H16-1096-23 - Land between A16 and Rangell Gate

Thank you for meeting with us on Monday to discuss the above anaerobic digester. Please see below some details we would like more info:

Figure 3 – MP1 Operational Hours Background Sound Level Analysis – Daytime

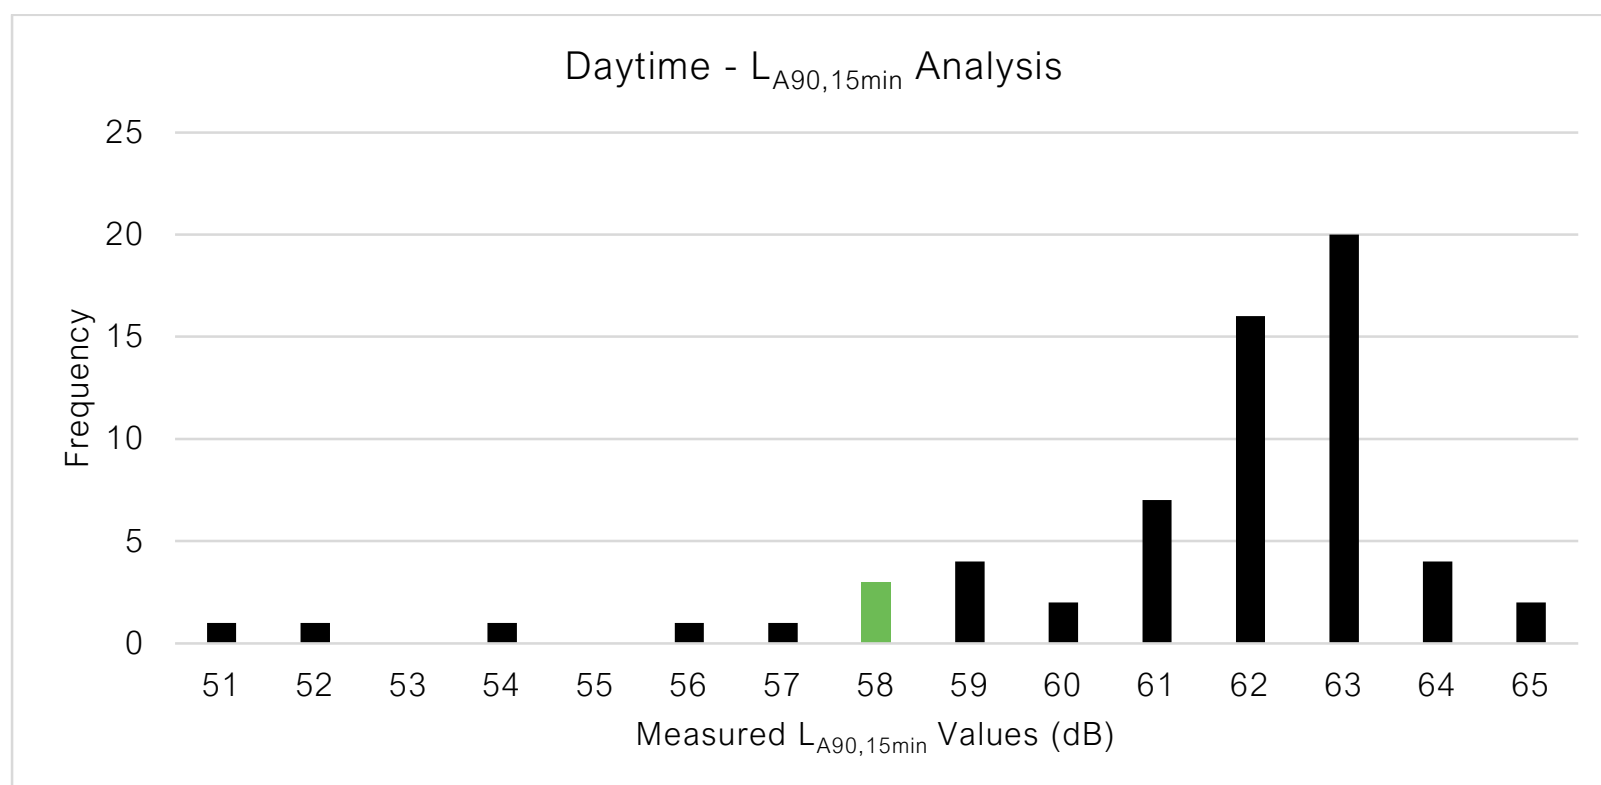
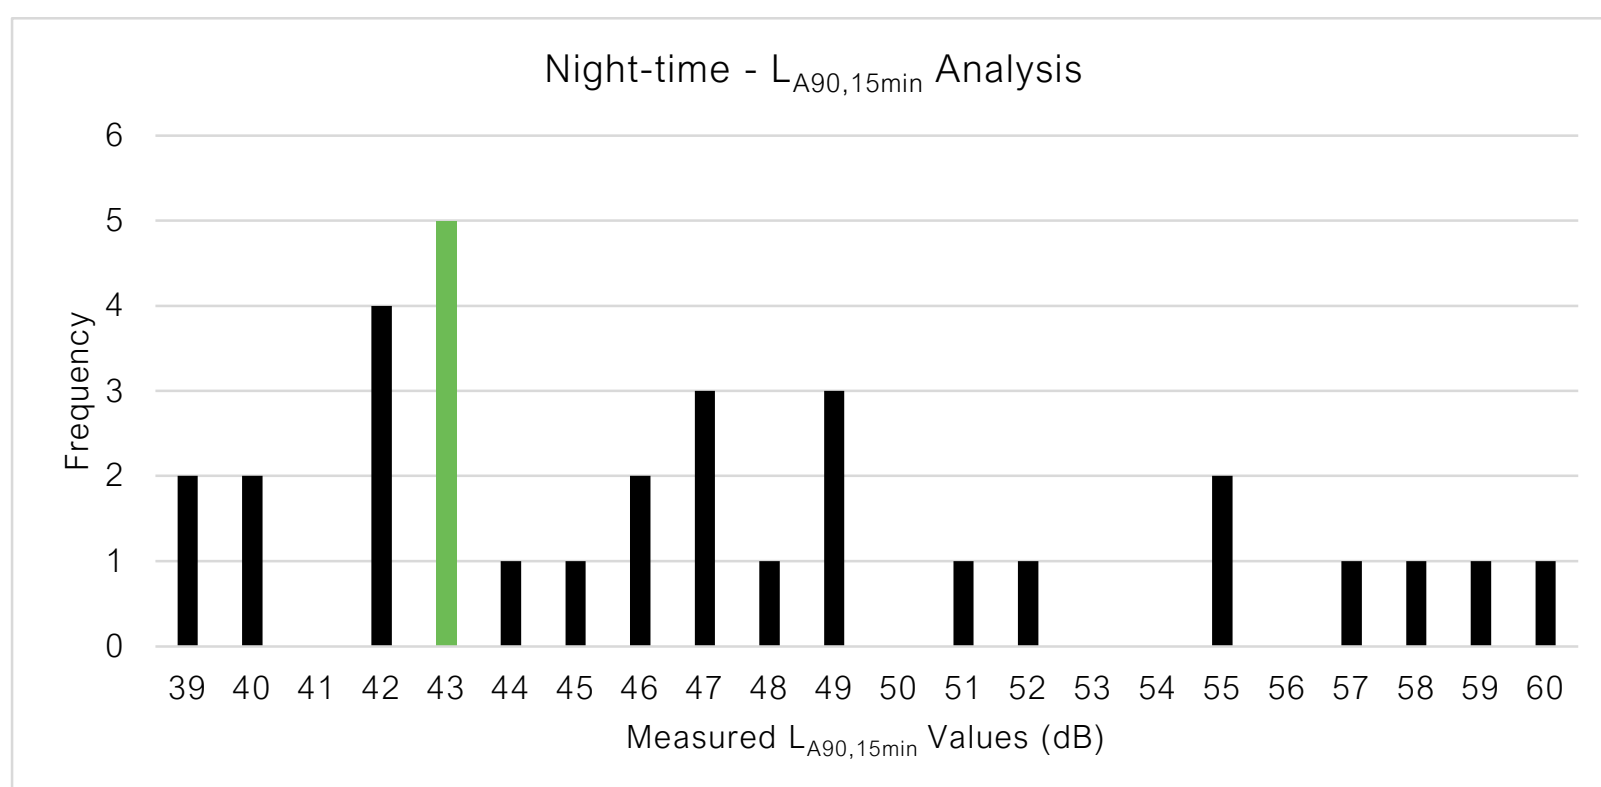
- How is it proposed to reduce the sound pressure level from the flare to 80dB? Is this technically possible?
- How is it proposed to liquify the CO2?
- Can they confirm the 'daytime' levels are up to 11pm? What was the background sound level (LA90, T) between 7pm & 11pm?

Figure 5 – Assumed Plant Locations

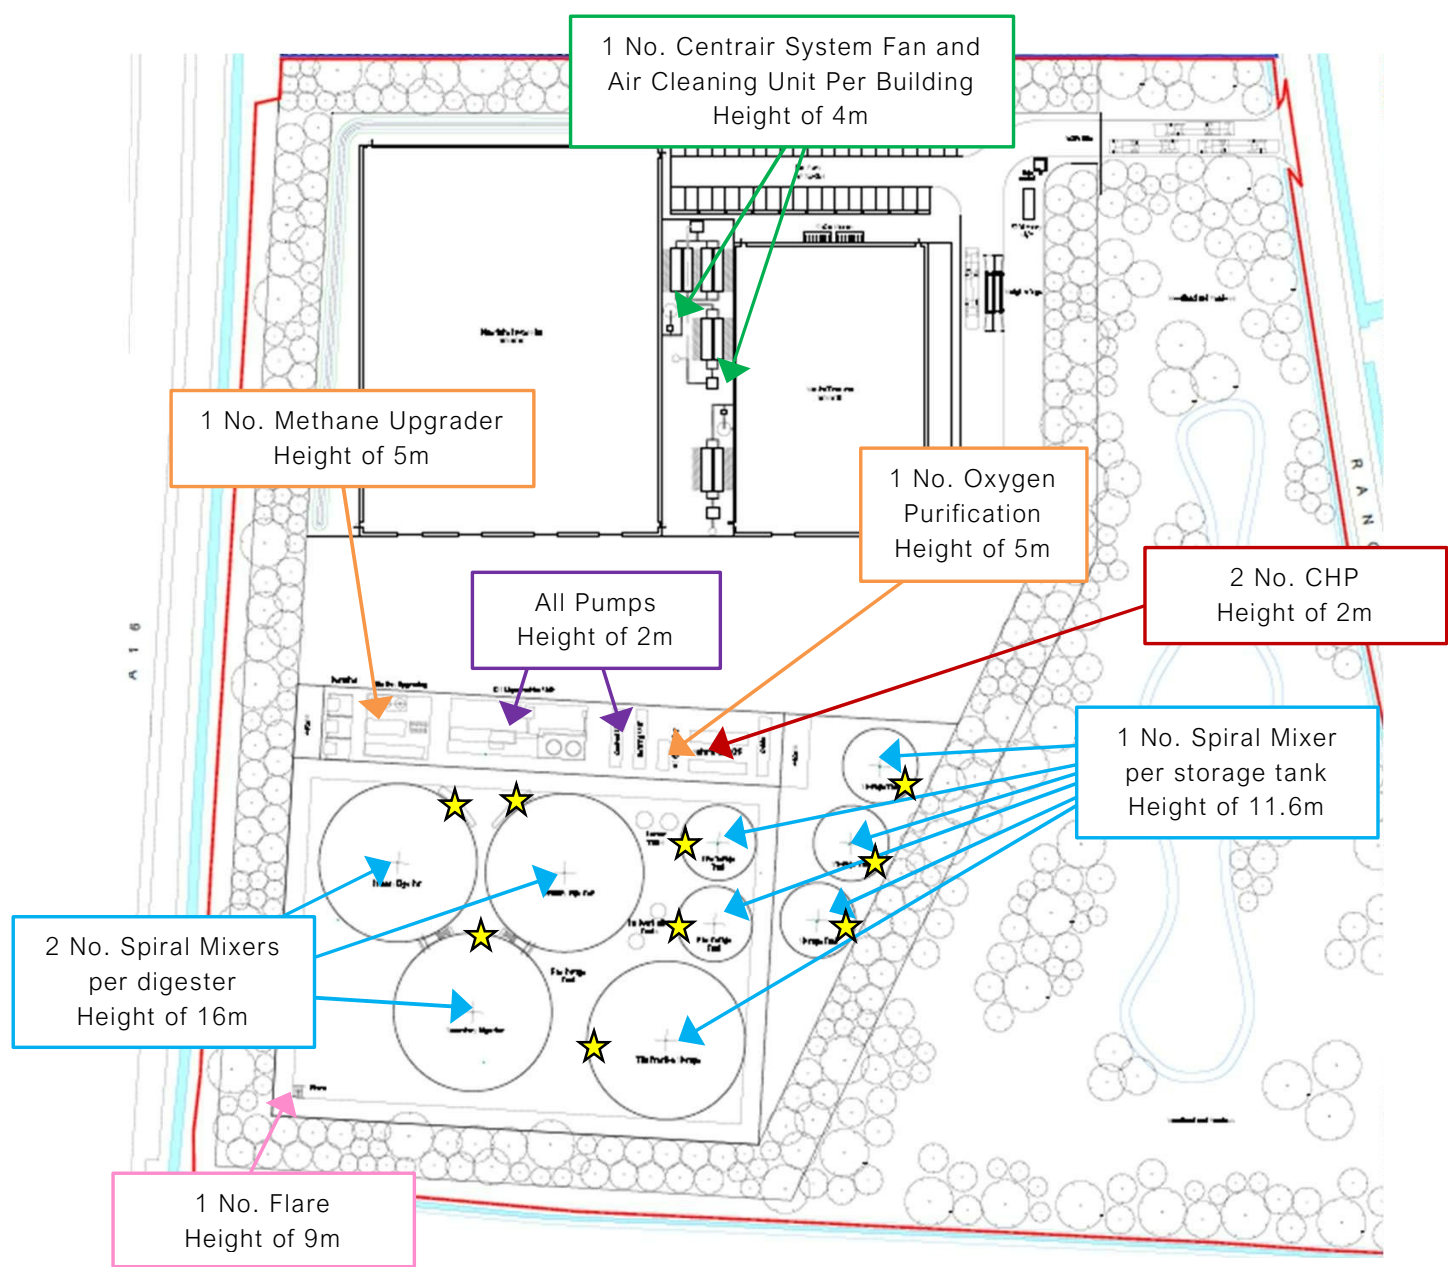
- We are particularly concerned regarding the roof mounted fans, and request specific information on their proposed location and type.
- Full Octave band analysis is requested.

Figure 8 – Night-time Specific Sound Level Map – 1.5 Grid Map Height – 2D

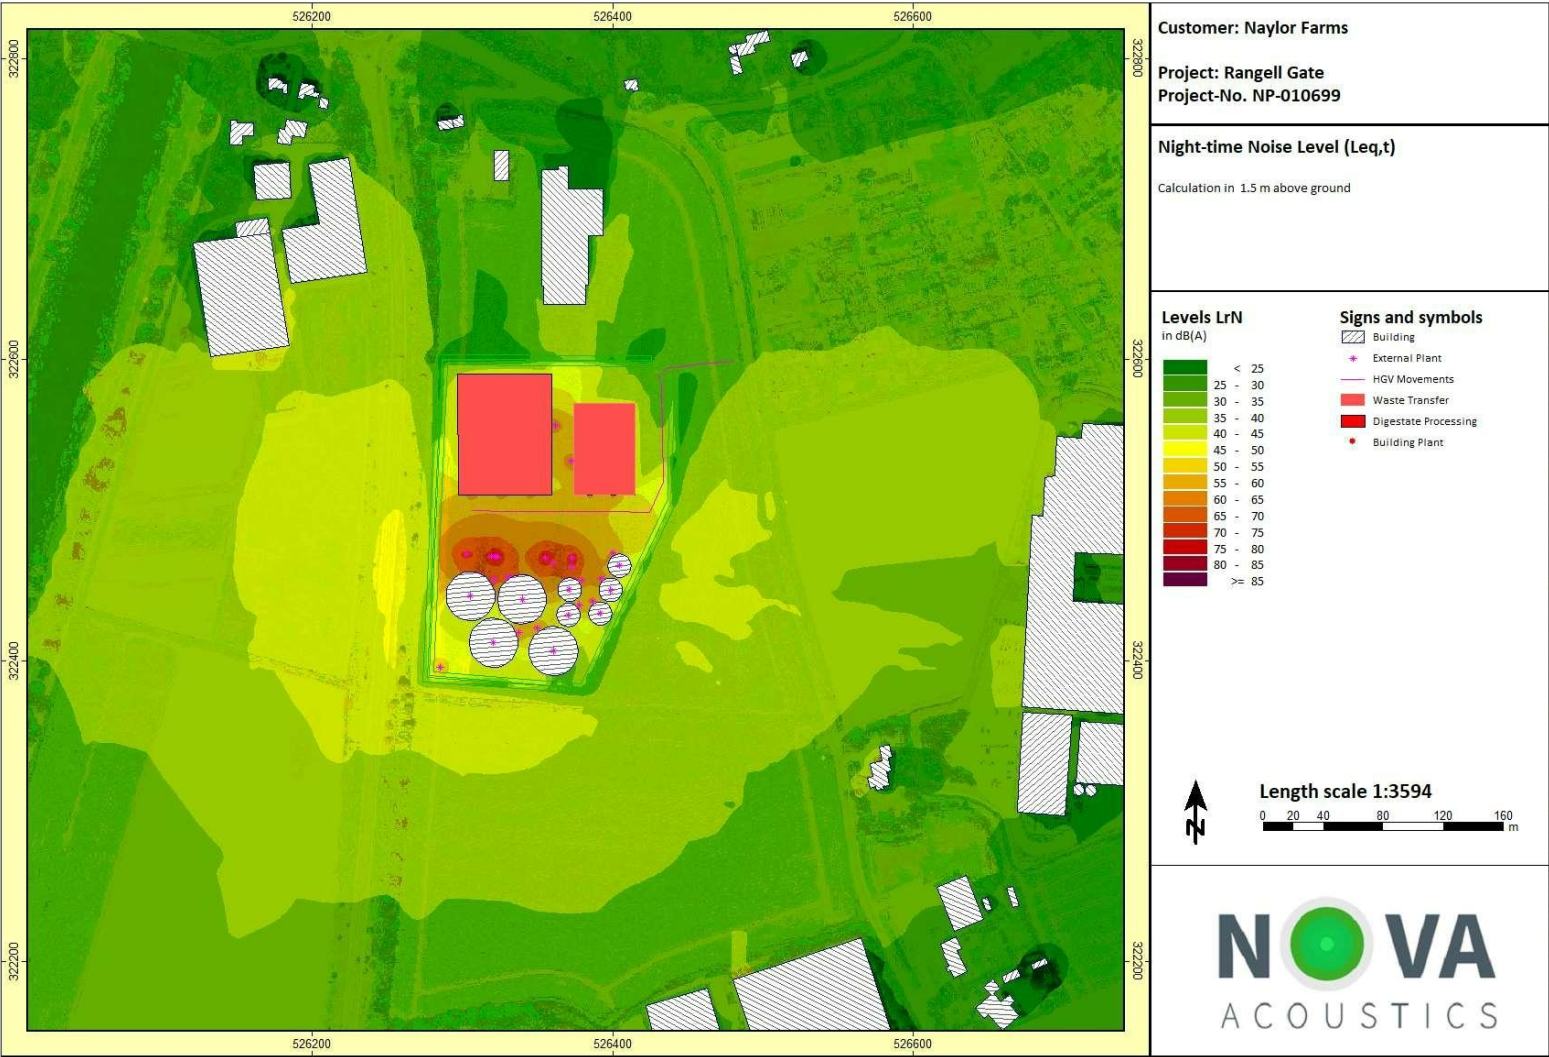
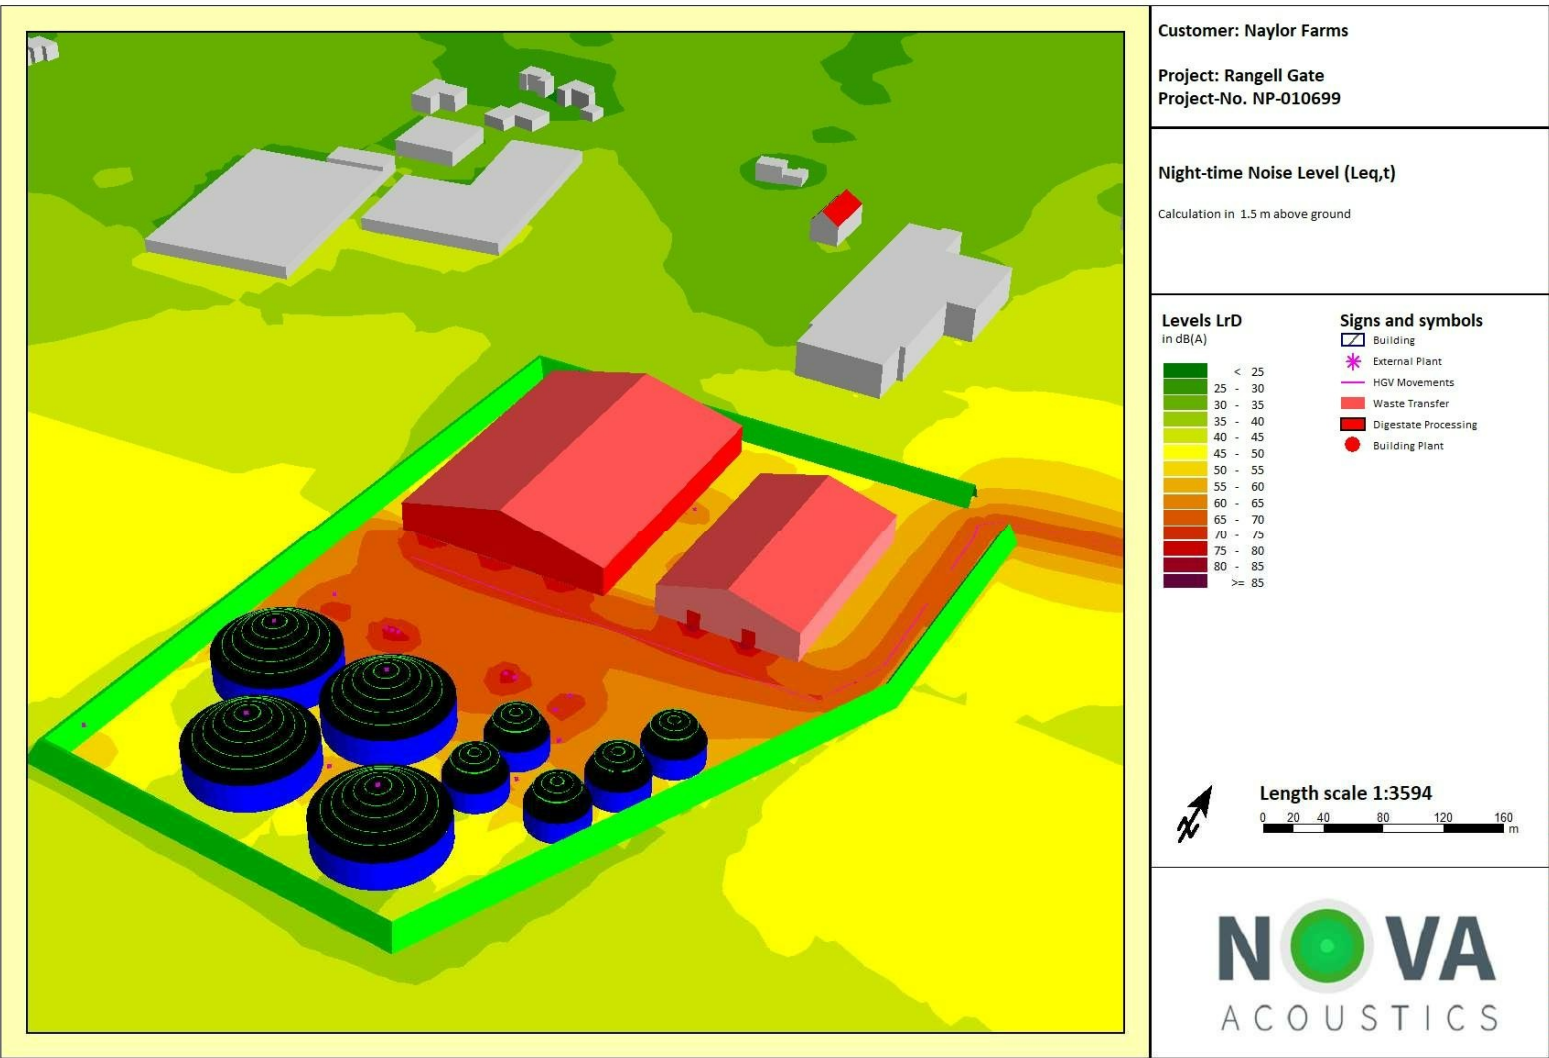
- Please could noise mapping at 3.5m be presented. This is more representative of the nighttime conditions nearby residents will be exposed to as the properties are two storey.
